# M20 Junction 10a

TR010006

## Applicant Responses to Kent County Council and Ashford Borough Council DCO Comments

Volume 14.2  
May 2017

RIGHTS OF WAY AND ACCESS PLANS
REGULATION 5(2)(k) & 5(2)(o)
SHEET 3 OF 4

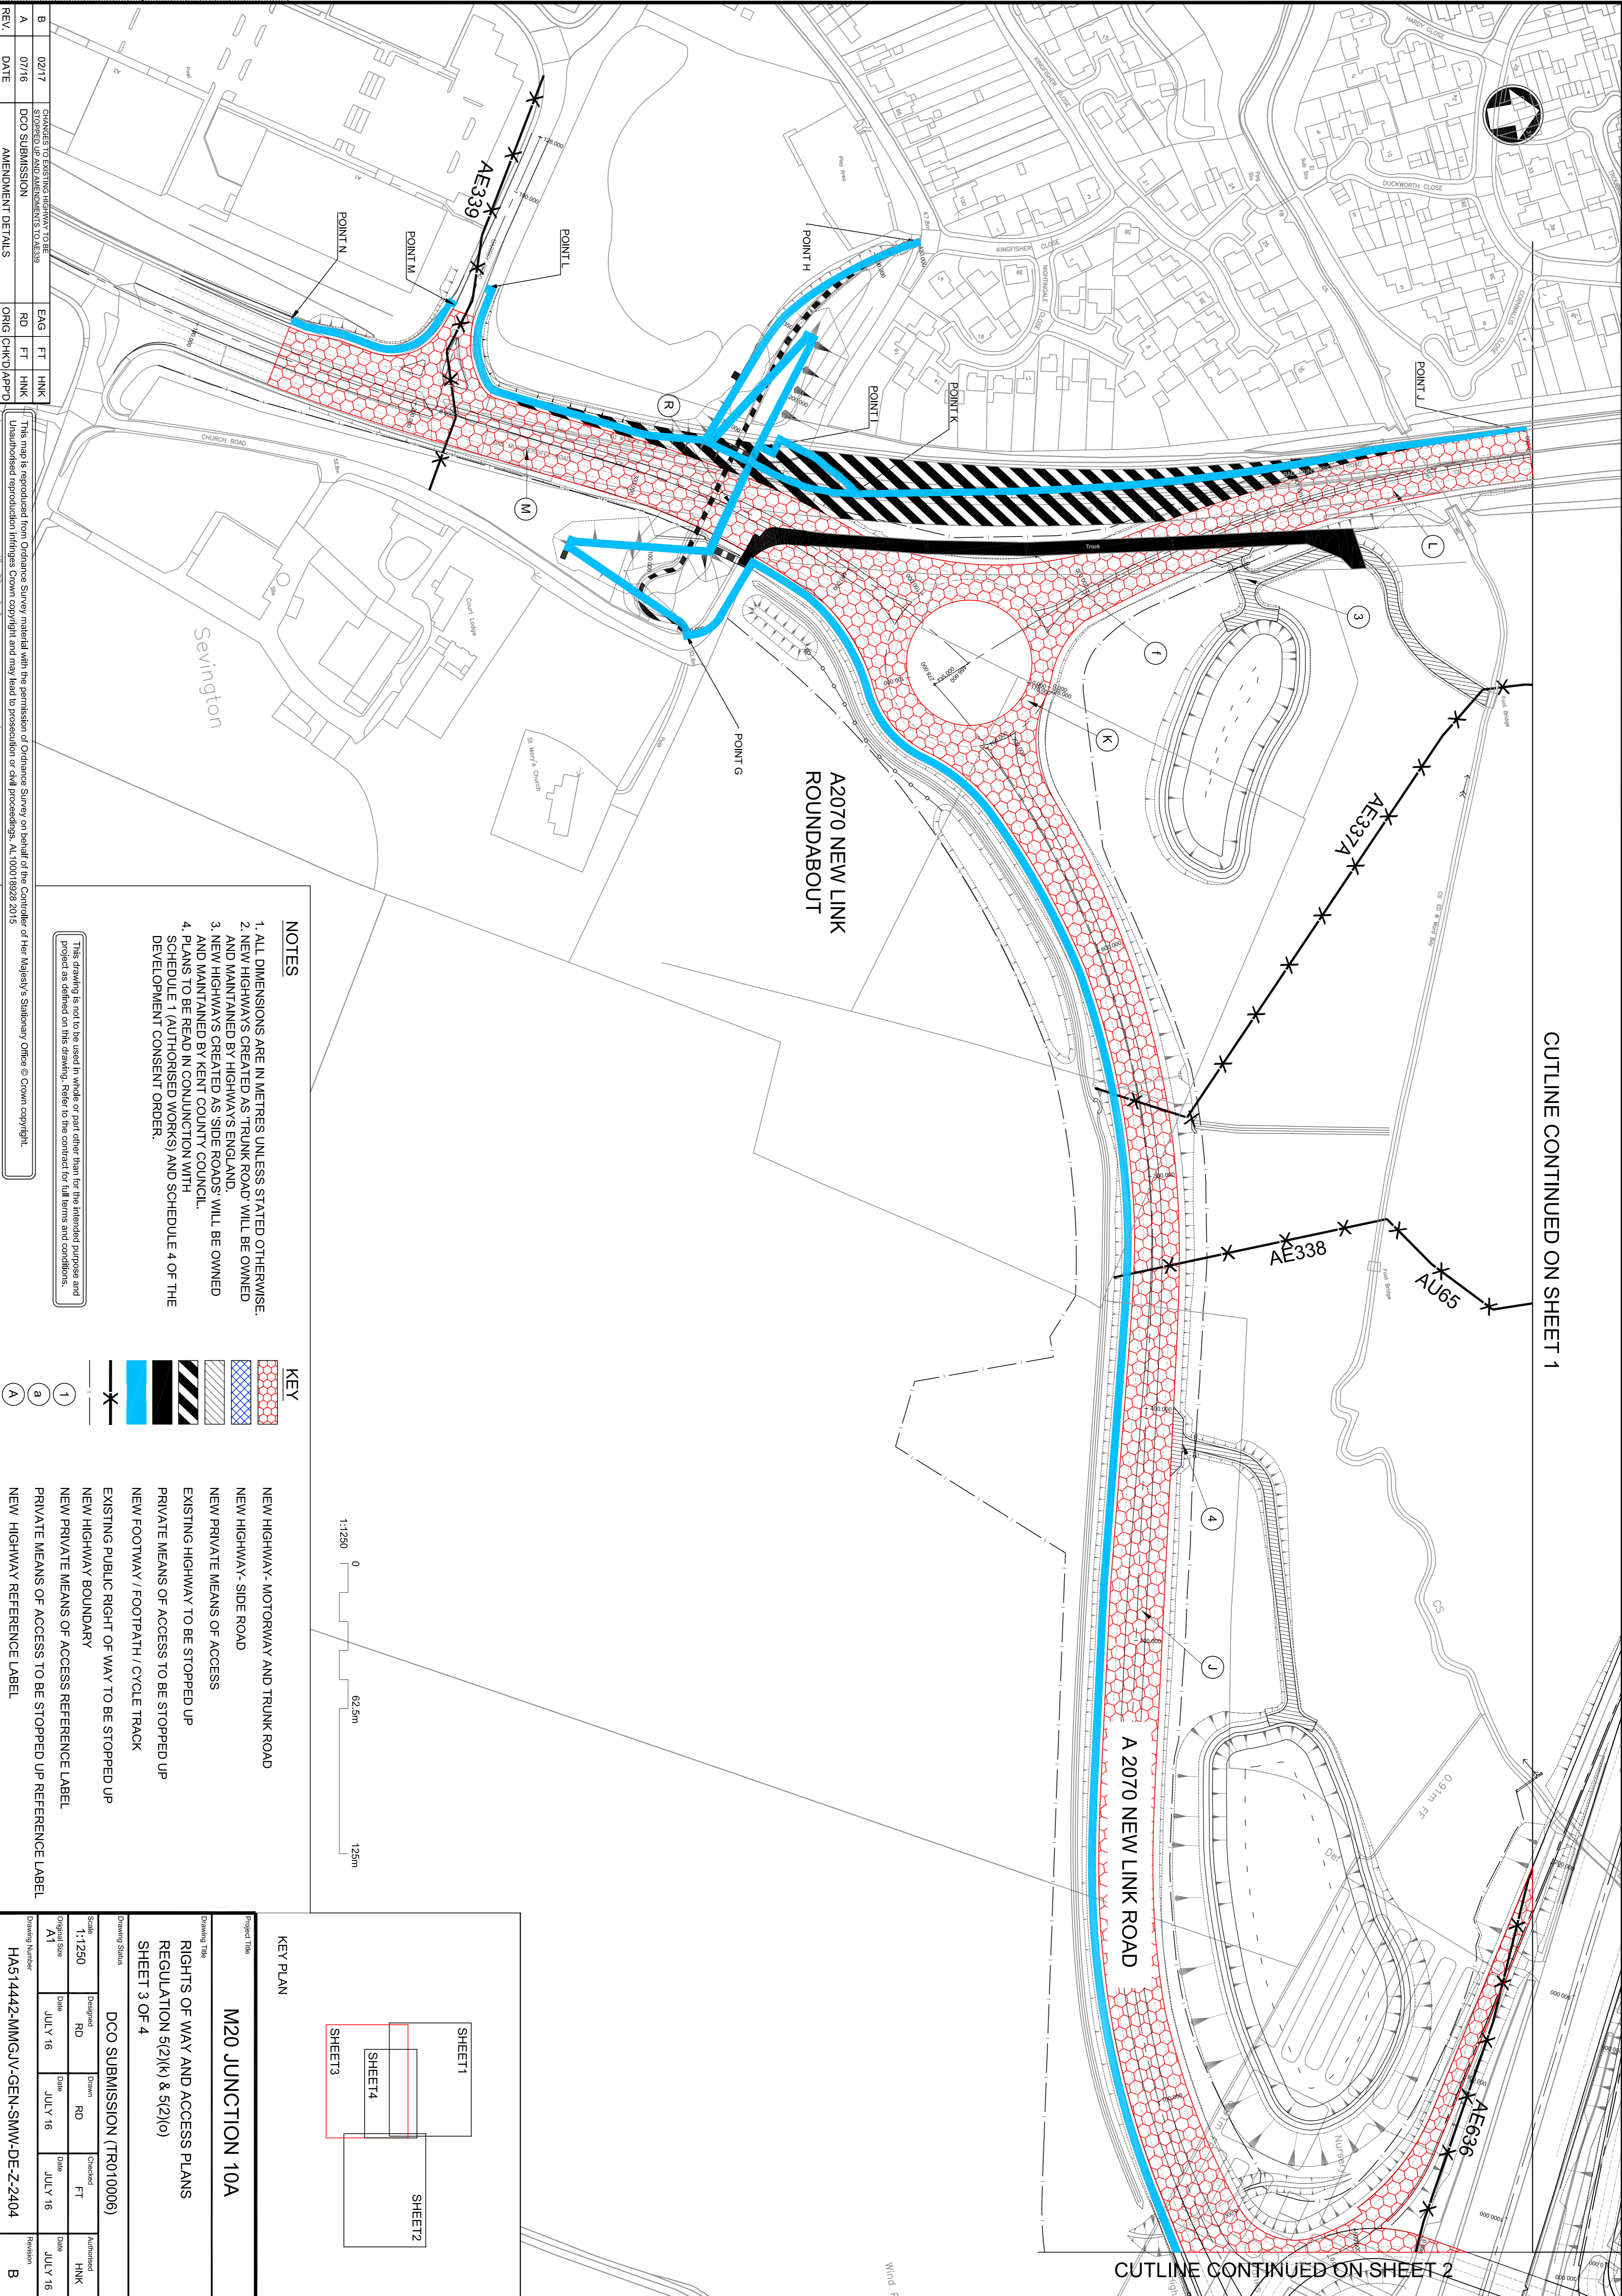
Article No	Comments from Kent County Council January 2017	Updated Comments from Kent County Council April 2017	Response from Highways England (the Applicant)
	<p>28 days is considered sufficient notice in line with statutory requirements. The map and description for PRow AE339, Sevington is incorrect. The Public Footpath extends across the A2070 to Church Road East of the A2070. The description and corresponding plan should therefore reflect the following;</p> <p>Parish – Sevington Highway to be stopped up – Public Right of Way AE339 Extent of stopping up – From the Barrey Road/Church Road junction West of the A2070 to where it meets Church Road again, East of the A2070 a distance of 184 metres, shown on sheet 3 of the rights of way and access plans.</p> <p>A copy of the made DCO at the date of making the Order and posting of the Order, must be sent to KCC's</p>		<p>submitted at Deadline 4. This shows footpath AE338 and AE339 (as well as others).</p> <p>Part 1 of Schedule 4 of the DCO has now been updated to include the correct details of footpath AE339.</p>

25	Yes KCC has approved the extinguishments.		An updated "Rights of Way and Access plans - Drawing No. HA514442-MMGJV-GEN-SMW-DE-Z-2404 (Rev B)" (PINS reference REP4-006) was
